CITY OF ALBUQUERQUE

June 29, 2022

**RE: Luxelocker
Conceptual Grading & Drainage Plan
Engineer's Stamp Date: 06/03/22
Hydrology File: B18D031**

Based upon the information provided in your submittal received 06/07/2022, the Conceptual Grading & Drainage Plan **is not** approved for action by the DRB on Site Plan for Building Permit. The following comments need to be addressed for approval of the above referenced project:

POND SECTIONS

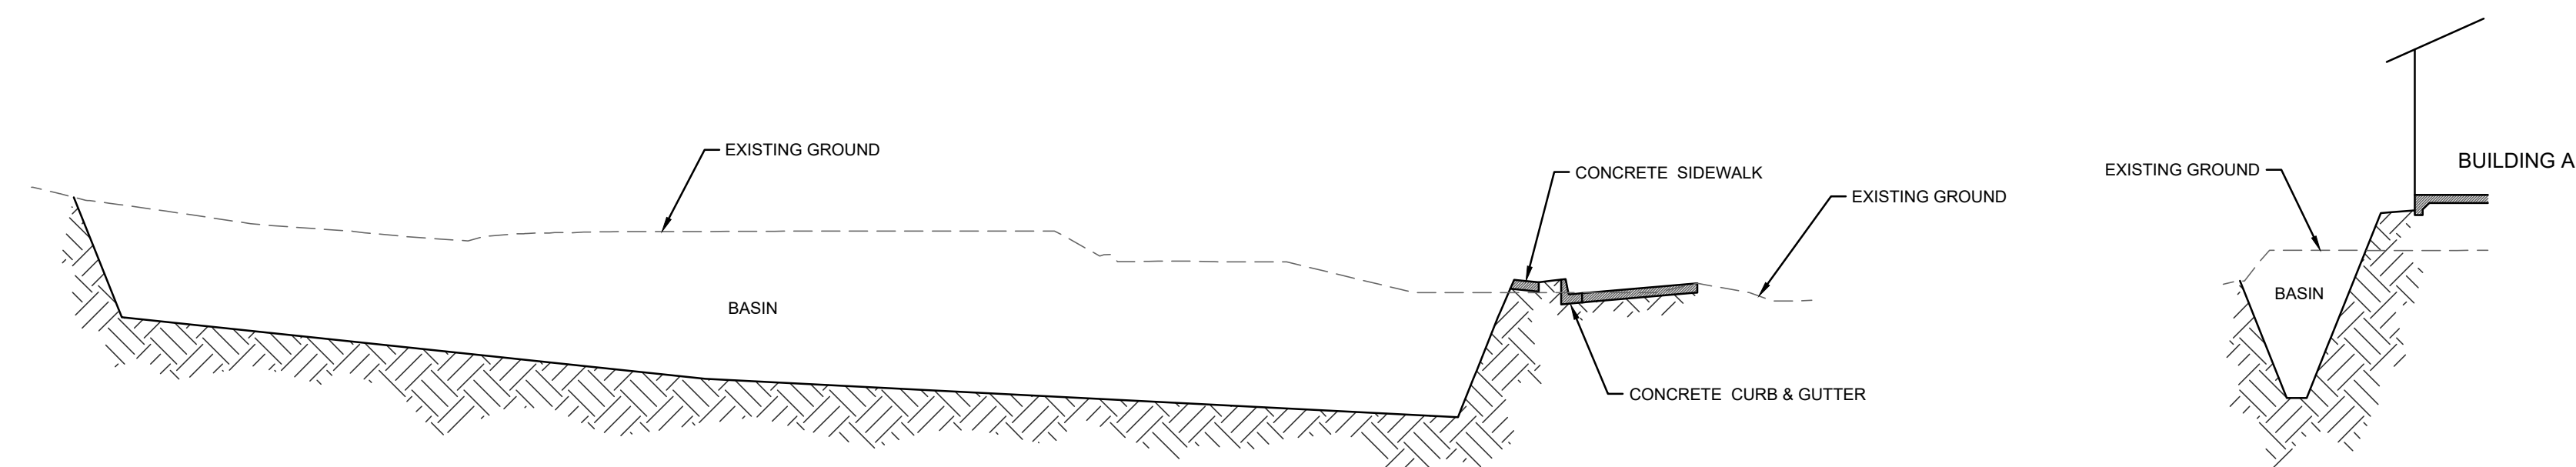
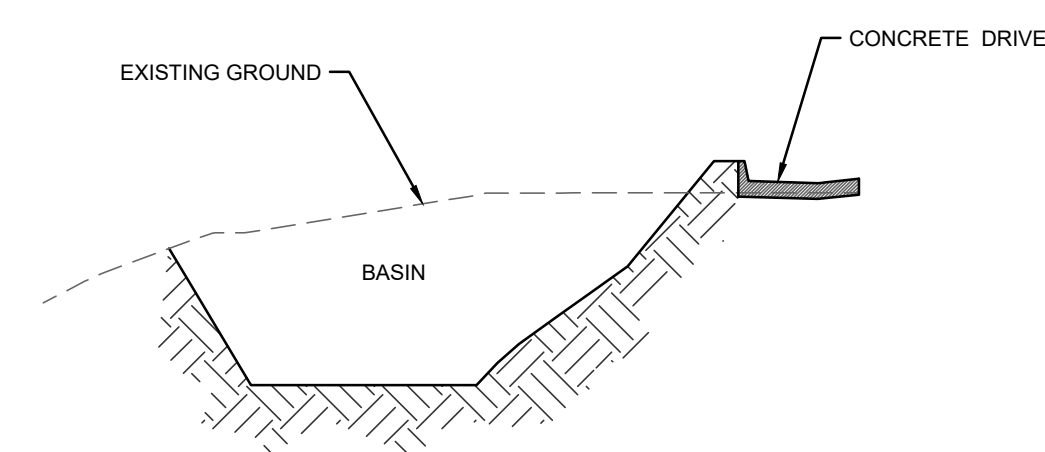
2. Hydrology also does need the Site's Cut & Fill calculation and the overall site sections. Hydrology does need sections through the stormwater quality ponds and through any retaining / garden walls (only if you have them).

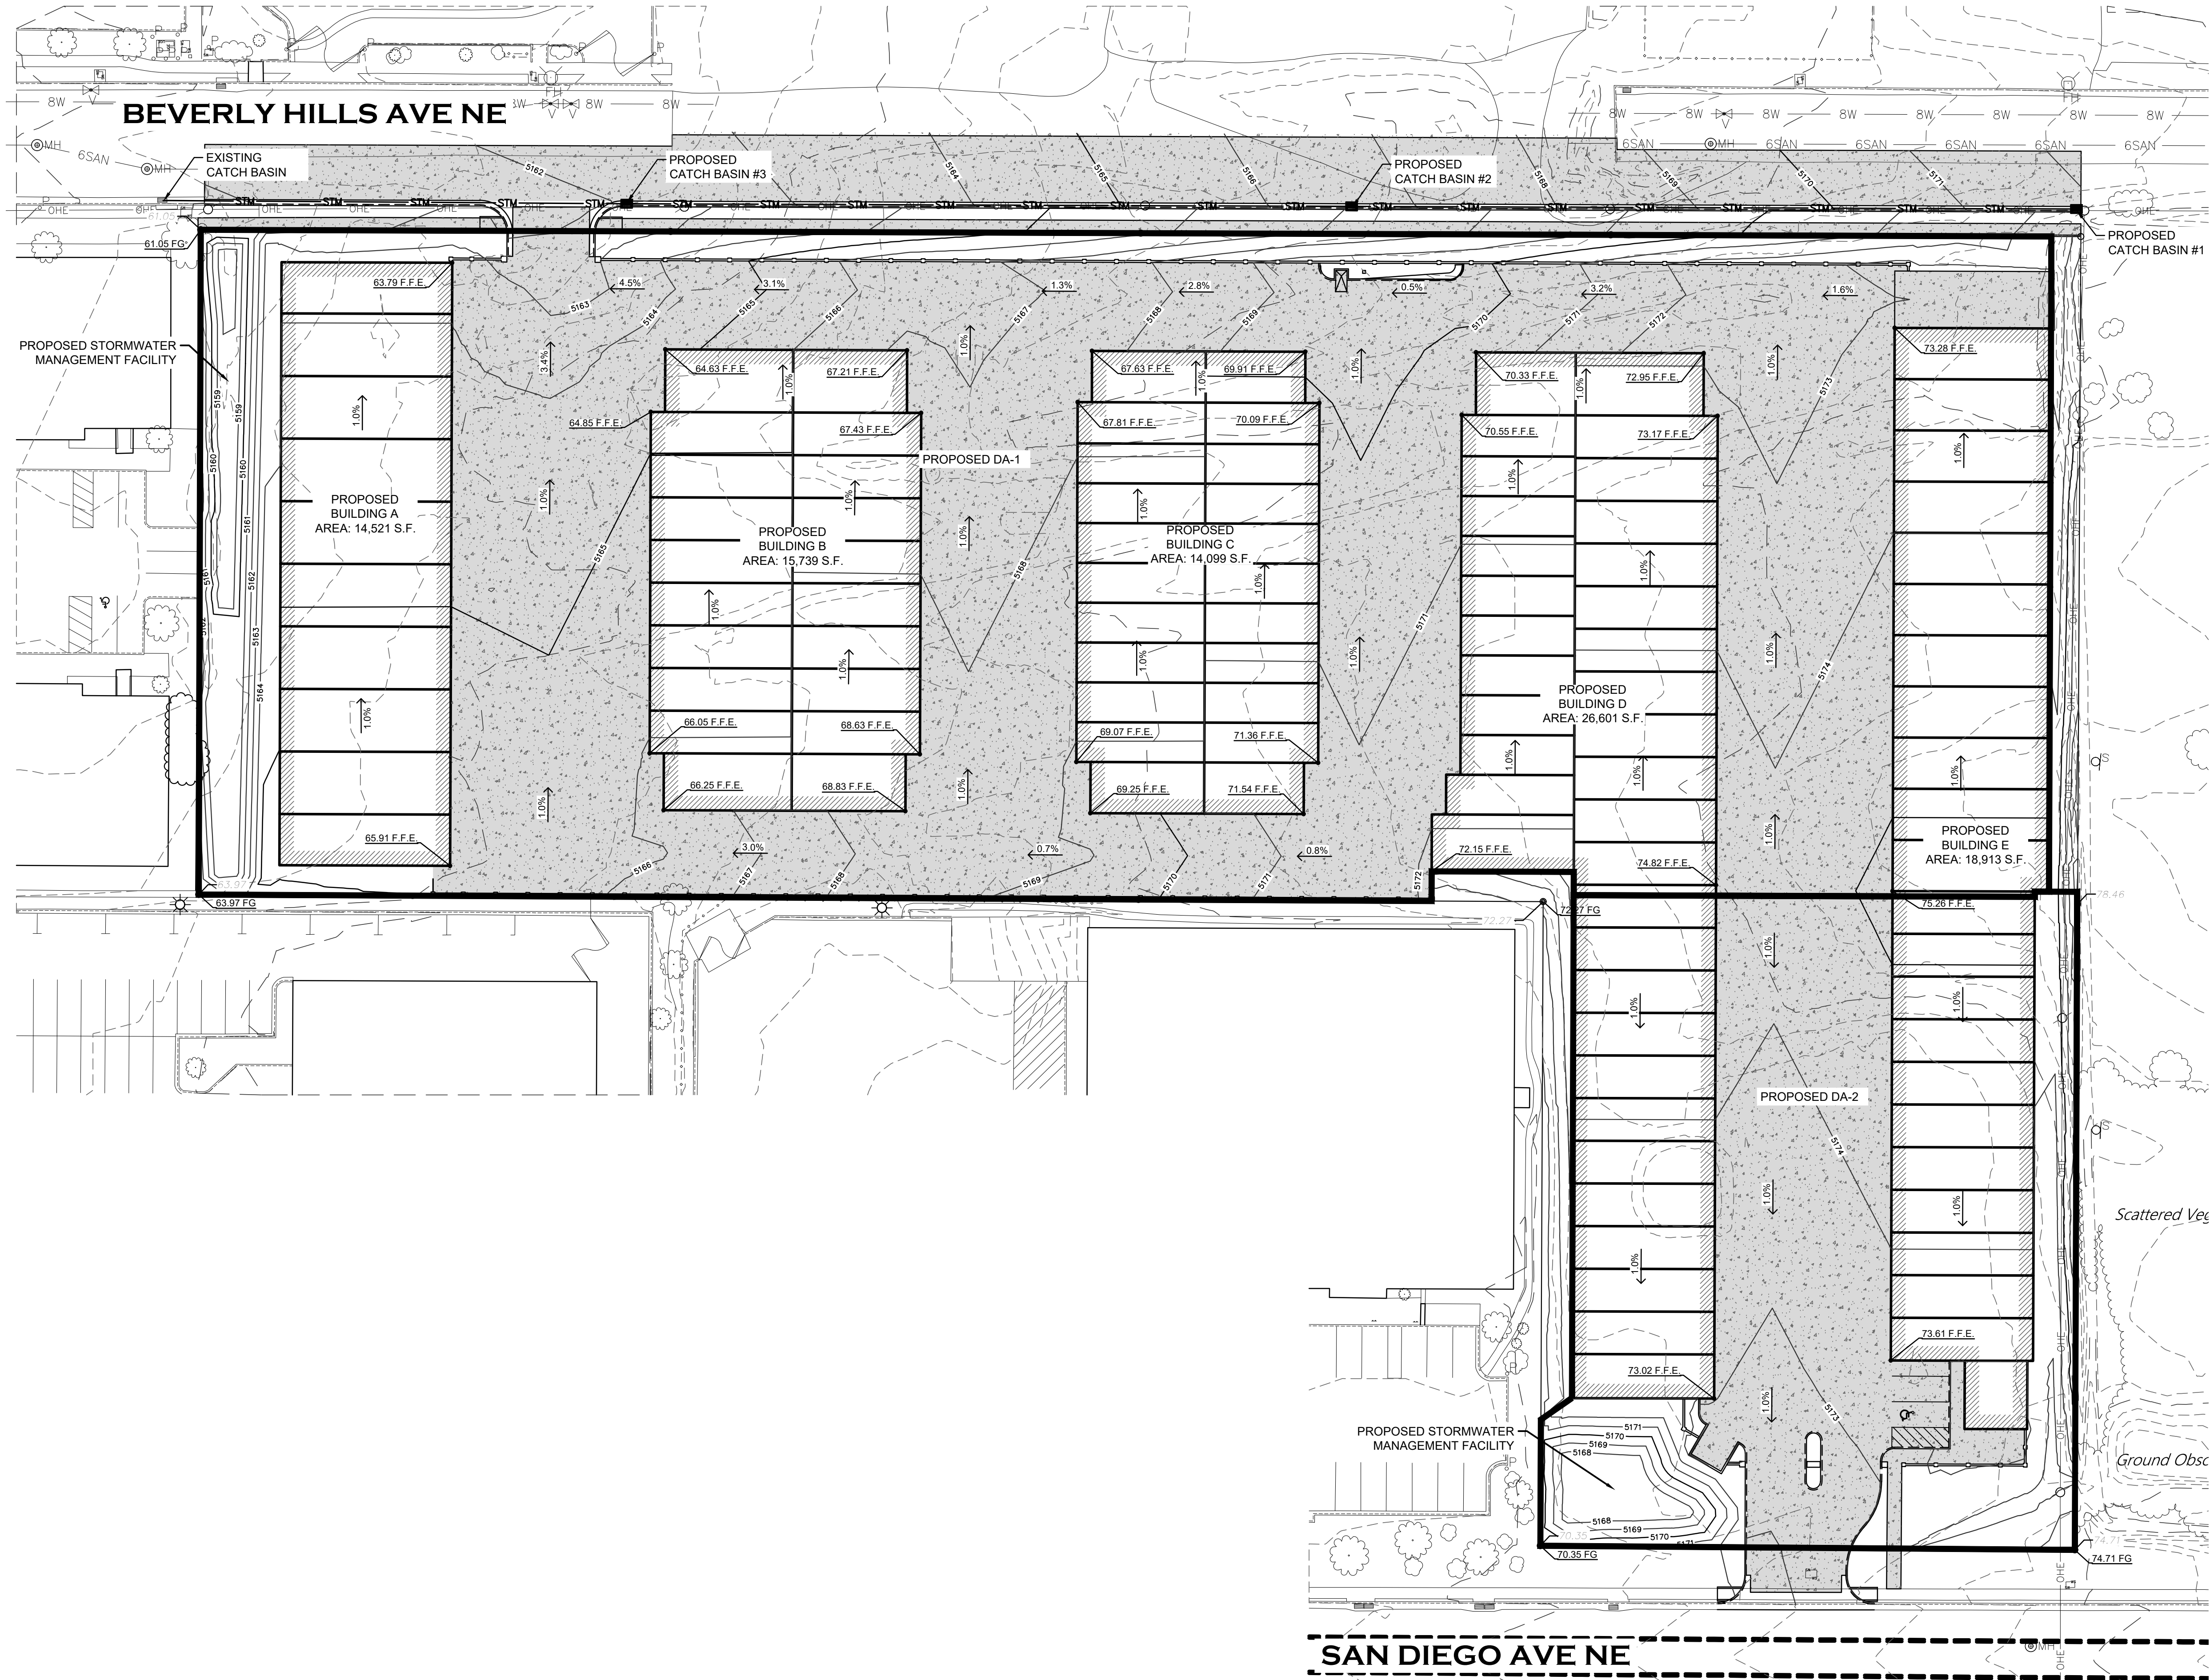
8. The whole grading needs to be revised. The entire site just drains directly to Beverly Hills without going into either of the required stormwater quality ponds as outlined in Comment #6.

9. There is currently off-site runoff that will be flowing directly into the development from the east. This flow needs to be calculated and shown. Please note that these flows are existing conditions and once this site is developed, the developed flows will discharge into Beverly Hills. So how is this development going to handle the existing condition off-site flows?

10. Need to calculate the south half of Beverly Hills street capacity as described in the DPM Article 6-9 Street Hydraulics. If the HGL or EGL is over the proposed top of curb, then an inlet will need to be installed. This inlet will then need to be connected to the existing 36-in storm sewer to the west on Beverly Hills.
